2023 Financial Assurance Estimate Form (with pre-plat construction)

PROJECT INFORMATION		
Space Village Filing No. 4	4/17/2023	MS227
Project Name	Date	PCD File No.

DRAINAGE CHANNEL PLAN

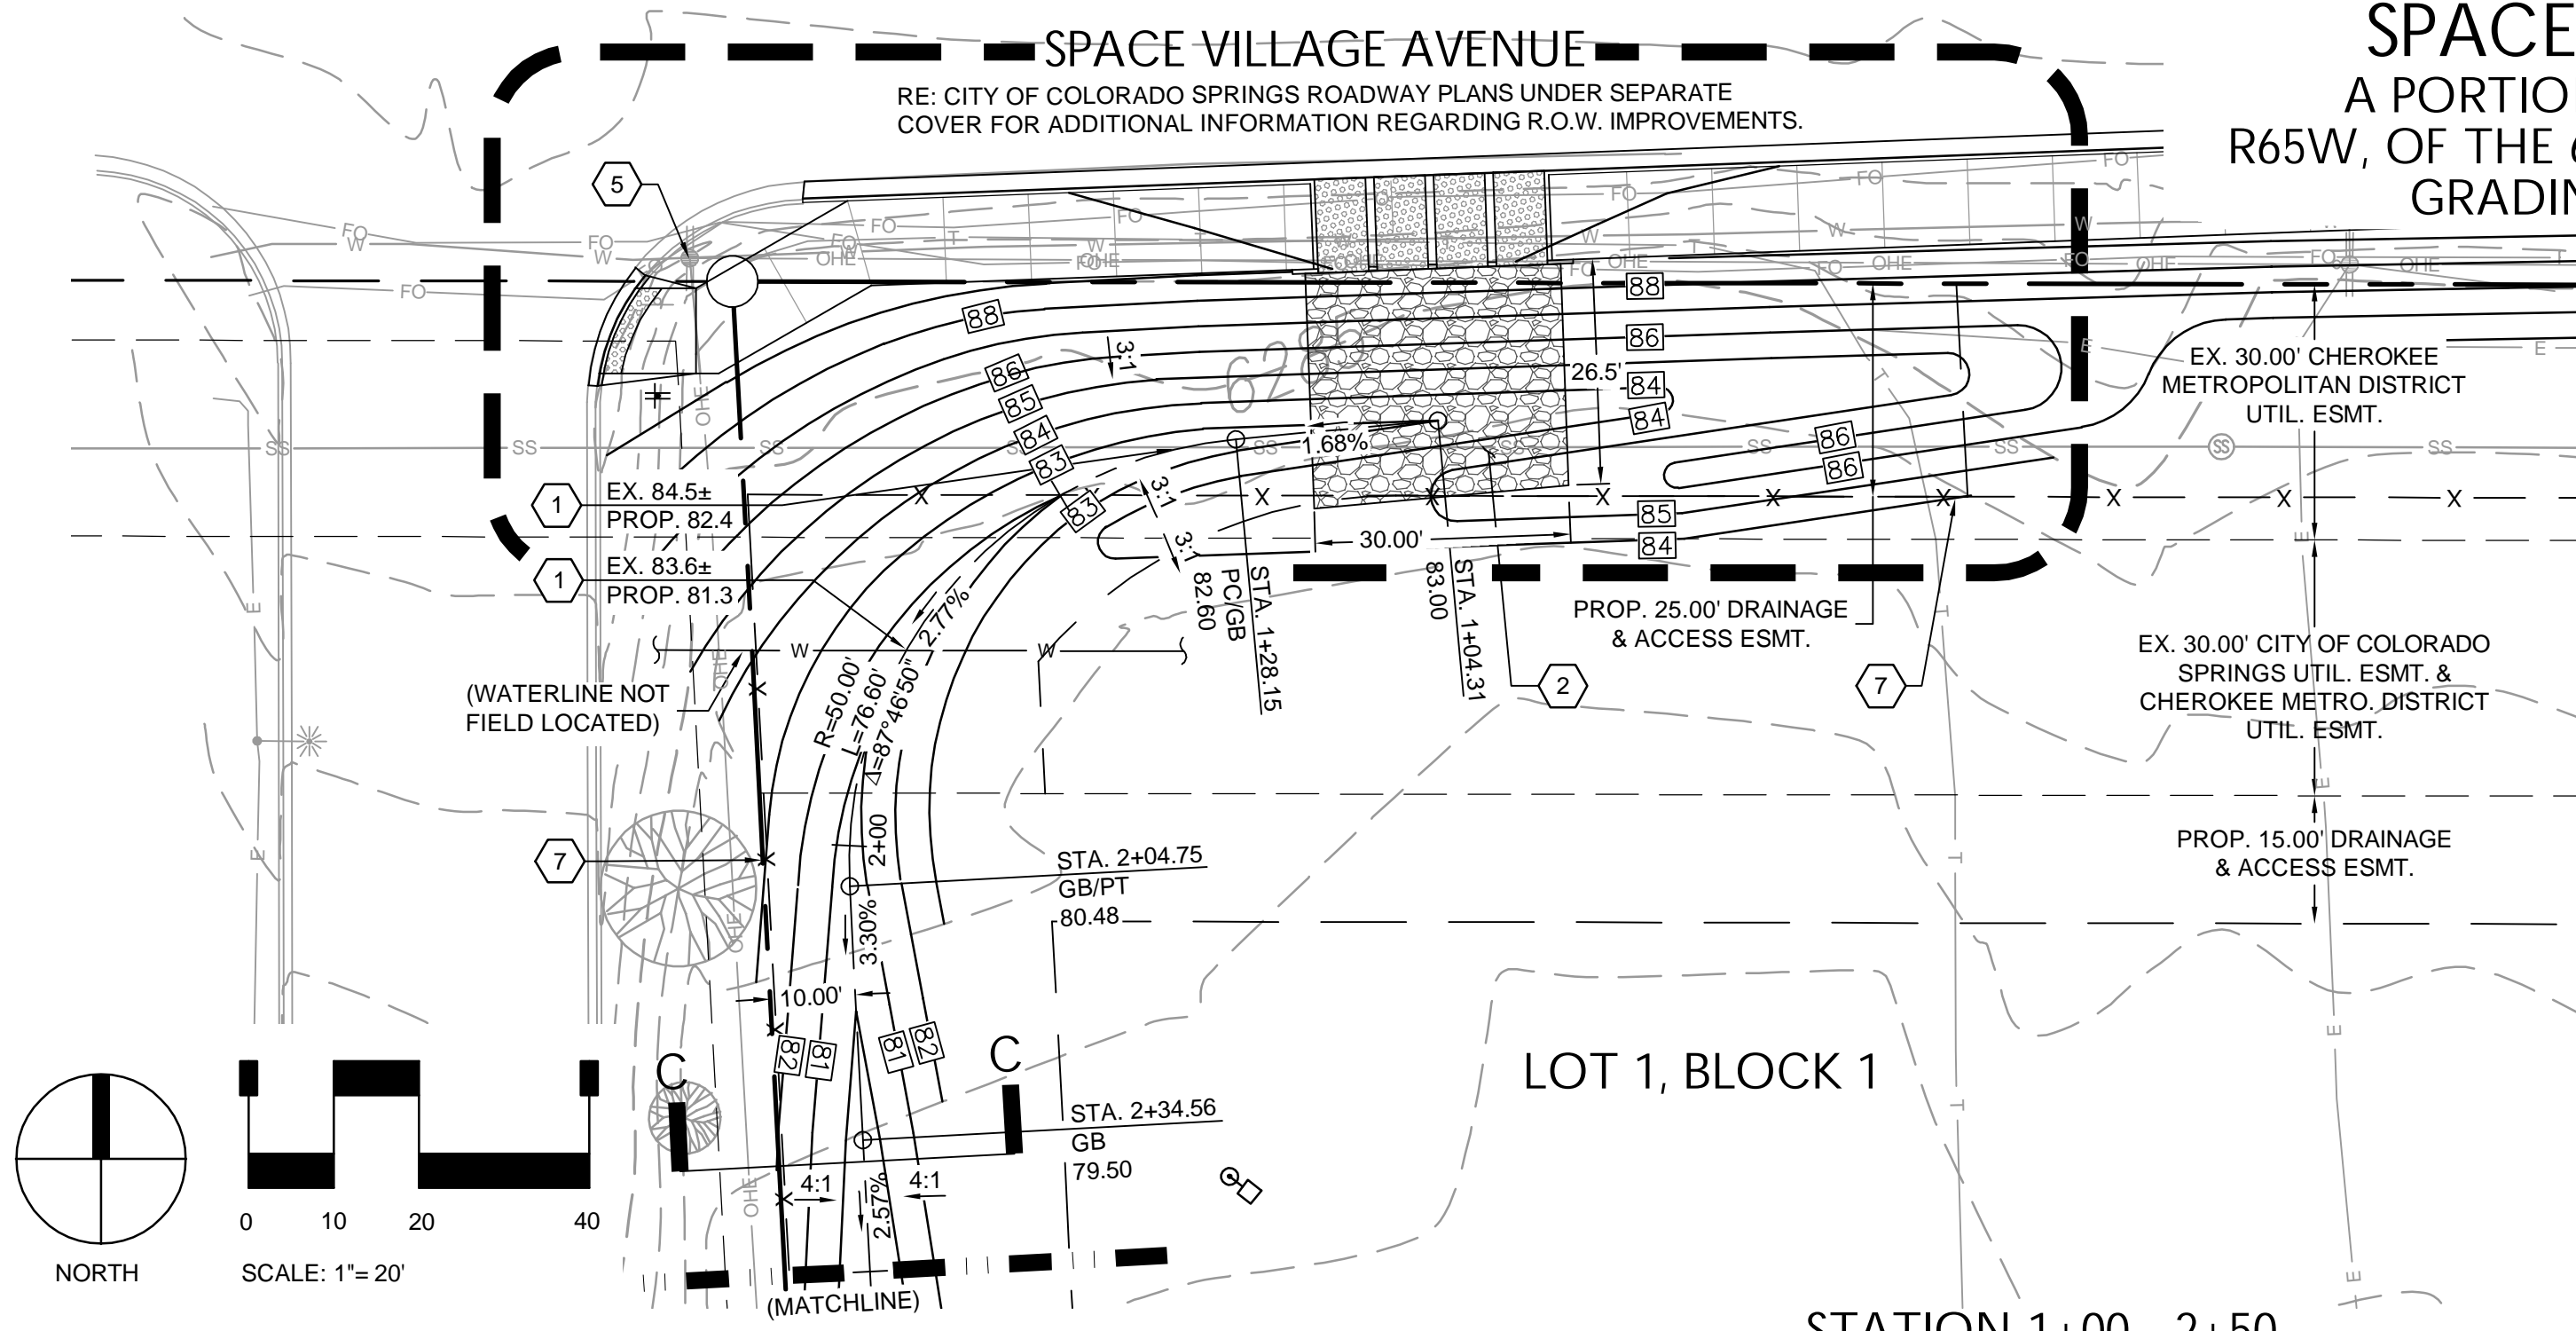
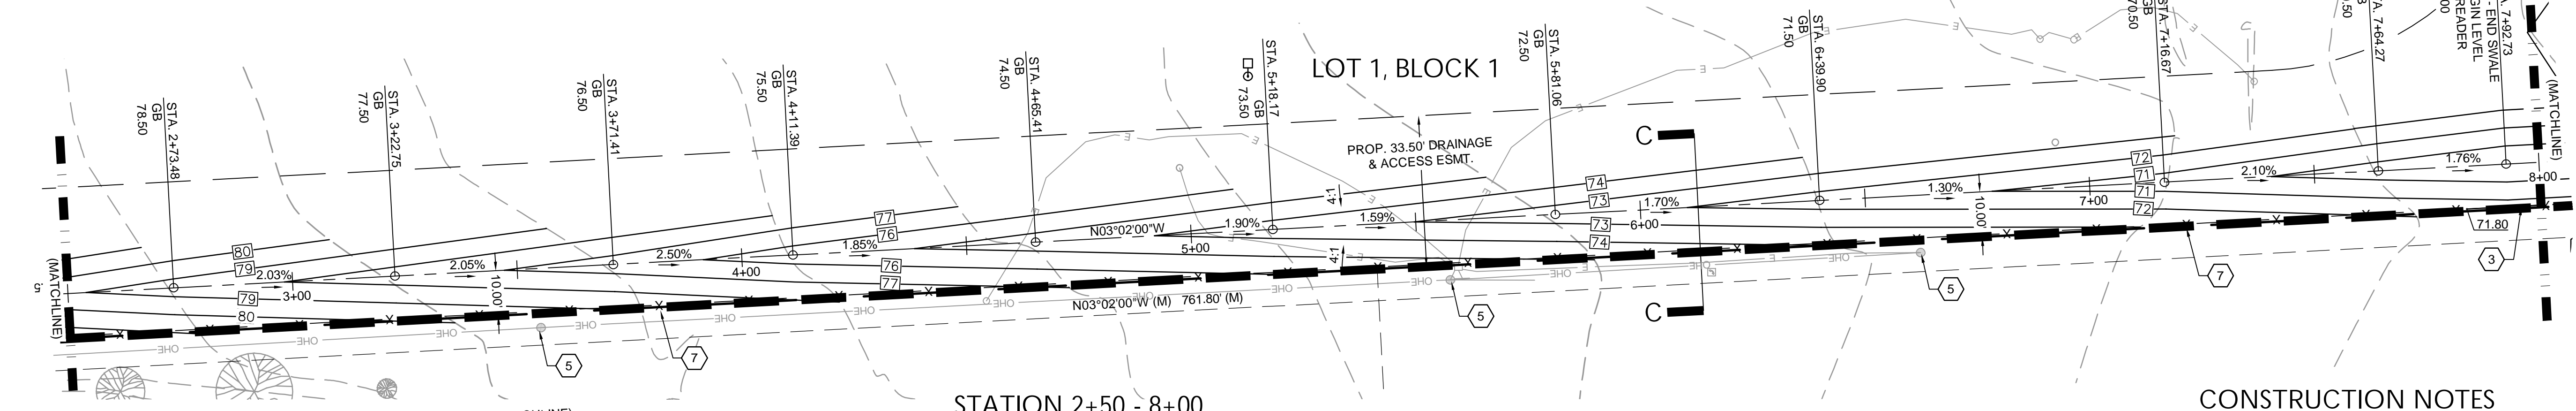
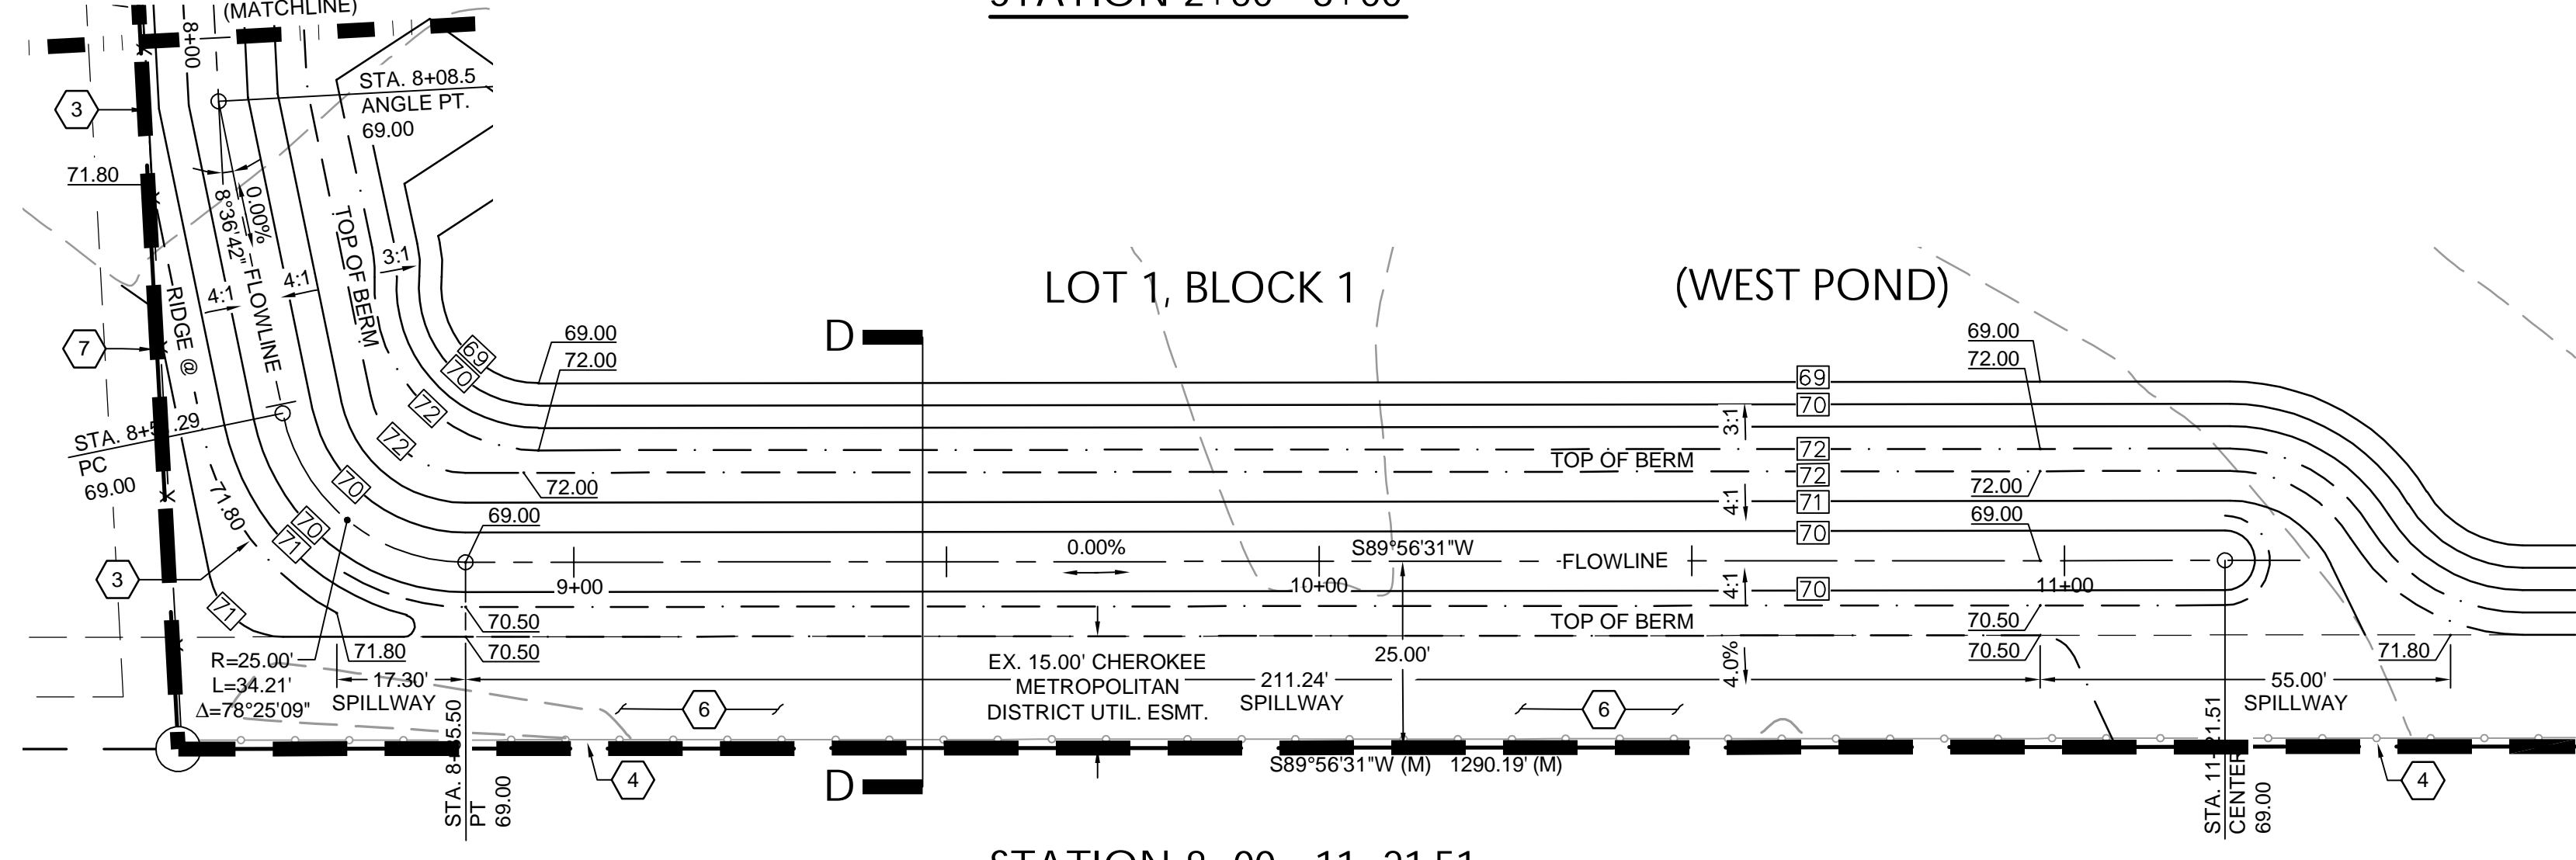
Fill out for the proposed channels and move them to section 3.

and level spreader

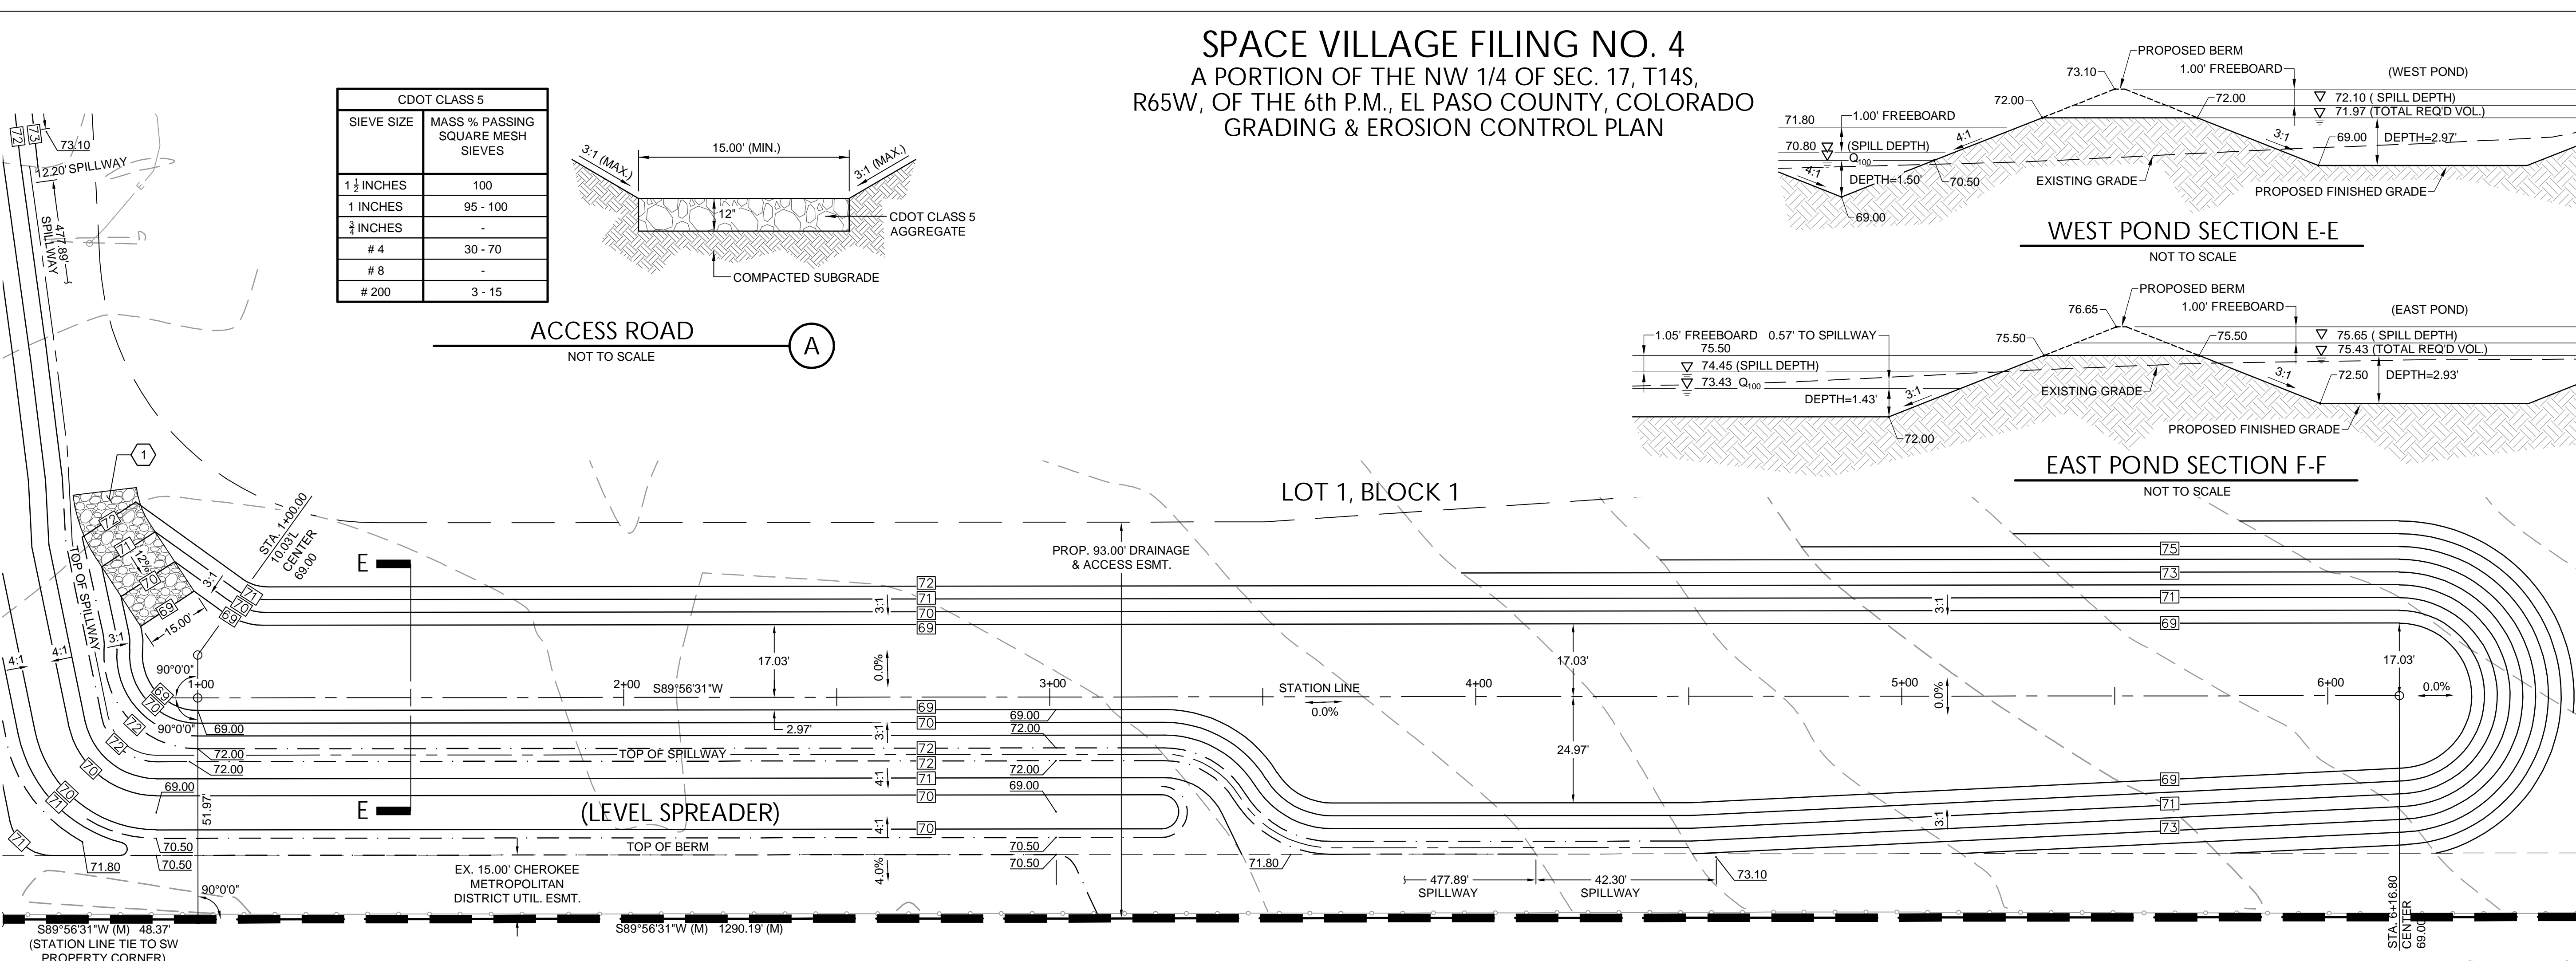
Be sure to include the two Sediment Traps or Sediment Basins on the 2023 FAE.
